STATE SIGNIFICANT DEVELOPMENT MP09_0074 MOD 3 – RESPONSE TO ADDITIONAL COMMENTS ON THE RESPONSE TO SUBMISSIONS

SRC Operations Pty Ltd (SRC Operations), a wholly owned subsidiary of Bingo Industries Limited (Bingo), own and operate the Patons Lane Resource Recovery Centre and Landfill (PLRRCL) located at 123 - 179 Patons Lane, Orchard Hills, New South Wales (NSW) (the site). SRC Operations are seeking approval under Section 4.56 of the NSW Environmental Planning and Assessment Act 1979 (EP&A Act) to modify (the modification) State Significant Development (SSD) consent MP09_0074 (the consent) to:

**Figure 4 | Patons Lane / Luddenham Road Intersection Proposed Upgrade Works (DA25/0955)**

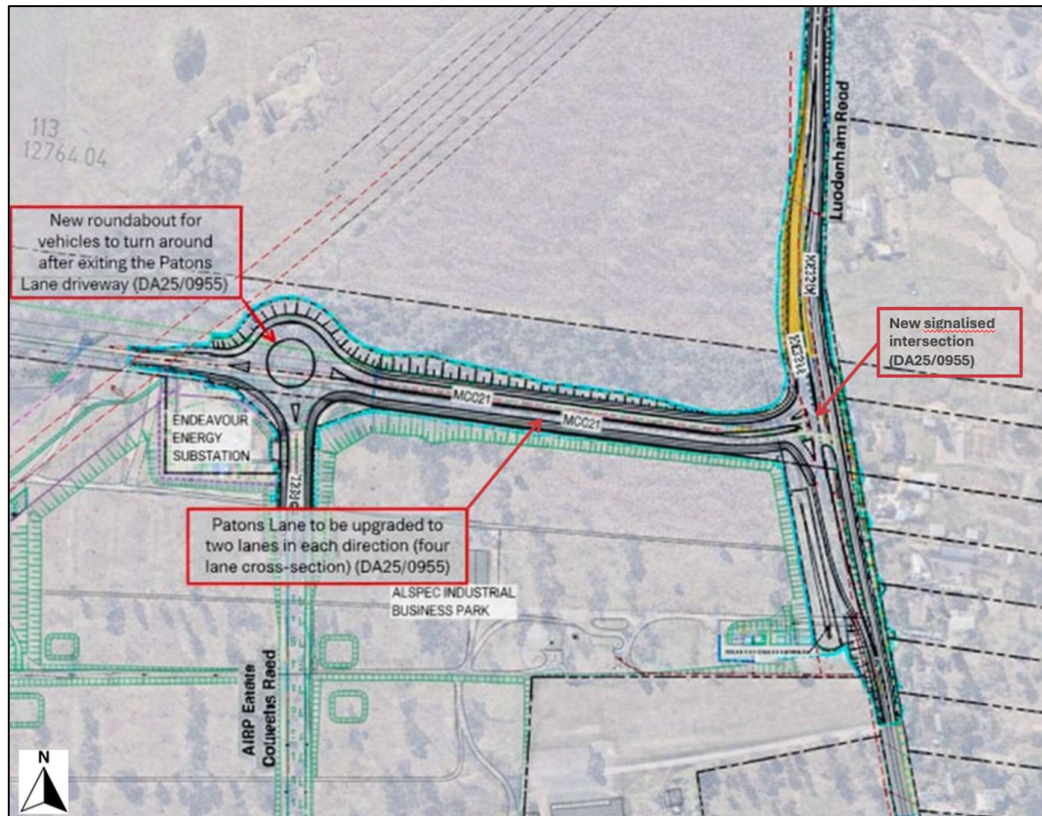
Comment	Response
The Department notes the modification relies on the delivery of the Luddenham Road / Patons Lane intersection upgrade (DA25/0955), which is not yet approved. Council and Sydney Metro have advised that the existing intersection does not have capacity to accommodate cumulative traffic from the proposed modification, AIBP and SMSMF prior to the intersection upgrades. The Department has also identified inconsistencies between the traffic survey data and Level of Service results in the revised Traffic Impact Assessment (TIA) provided in the Submissions Report compared with traffic data presented in DA25/0955.	SRC Operations acknowledges the Department's observations and confirms that the reference in the RTS Report to DA25/0955 being "approved" was a typographical error. DA25/0955 remains under assessment by Penrith City Council and has not yet been determined. Importantly, SRC Operations does not rely on the intersection upgrade being in place to support operation of the modification proposal. In direct response to the concerns raised by Sydney Metro and Council regarding the adequacy of the traffic survey data, updated traffic modelling has been prepared by SCT Consulting (February 2026) provided at Attachment A. The updated modelling adopts the March 2025 survey data used in the AIBP DA25/0955 traffic impact assessment (TIA) — the most current available dataset incorporating Sydney Metro construction traffic — as the baseline for all cumulative assessment scenarios. This directly resolves the data inconsistency identified by the Department. It is also important to note that all parties — SRC Operations, Sydney Metro and the AIBP proponent — agree that once the proposed intersection upgrade is delivered, there are no

Notwithstanding that DA25/0955 is yet to be approved by Penrith City Council, the construction impact on Patons Lane and Luddenham Road is expected to be significant during the construction phase of the road works. At this stage, it is not clear whether two-way vehicle

SRC Operations has undertaken additional consultation with AIBP to identify how traffic will be managed during their intersection upgrade works. AIBP have detailed that they will be staging the intersection upgrade to construct the carriageways offline. This will allow ongoing two-way traffic on Patons Lane during construction.

The draft staging plan for the intersection upgrade works showing how the traffic flows on Patons Lane would be maintained, is provided at Attachment B. Note that construction of the proposed intersection upgrade is not yet approved and SRC Operations is not the proponent of that project.
